Kirklees Council
Planning and Development Service
PO Box 1720
Huddersfield
HD1 9EL

Our Ref: 2023/91250
Date: 20-Jun-2023

**TOWN AND COUNTRY PLANNING ACT 1990
TOWN AND COUNTRY PLANNING (GENERAL PERMITTED DEVELOPMENT)
(ENGLAND) ORDER 2015 - APPLICATION NO:2023/N /91250/E
DEVELOPMENT: PRIOR NOTIFICATION FOR PROPOSED 15M 5G TELECOMS
INSTALLATION: H3G STREET POLE AND ADDITIONAL EQUIPMENT CABINETS
OWL LANE, SHAWCROSS, DEWSBURY, WF12 7RQ**

Title: **265 PROPOSED SITE ELEVATION**

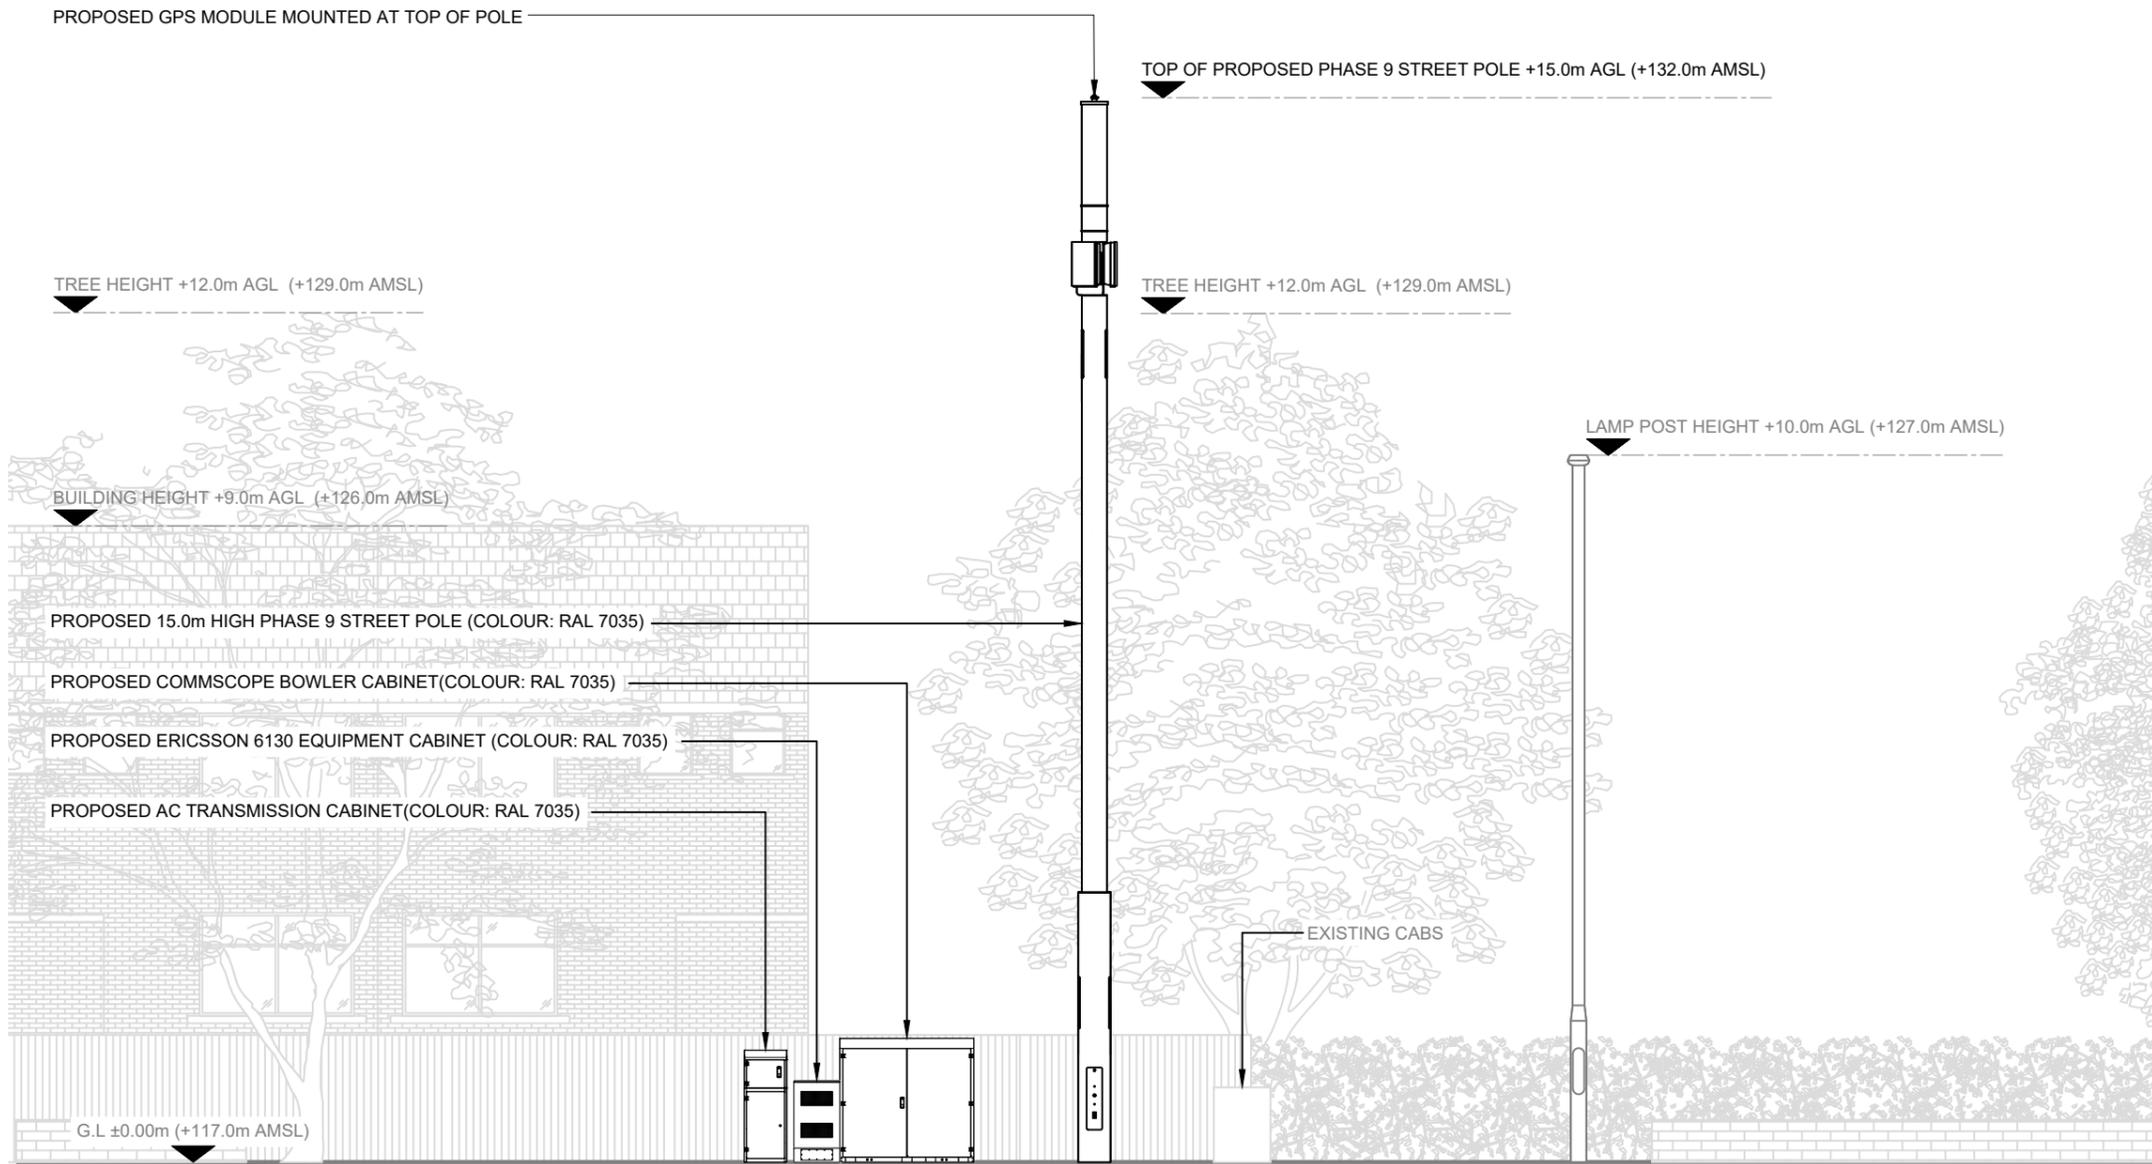
The proposed mast, by reason of its siting, size, and appearance would be a visually intrusive and incongruous feature in the streetscape appearing wholly out of scale with the surrounding residential properties and failing to respect the character of the area. The proposed development would therefore be contrary to Policy LP24 of the Kirklees Local Plan and Chapters 10 & 12 of the National Planning policy Framework. In addition the applicant has not demonstrated that any site/building closer to or within the nearby industrial area cannot be discounted in so far as the proposed location is the only reasonable location to achieve the aims of chapter 10 of the National Planning Policy Framework.
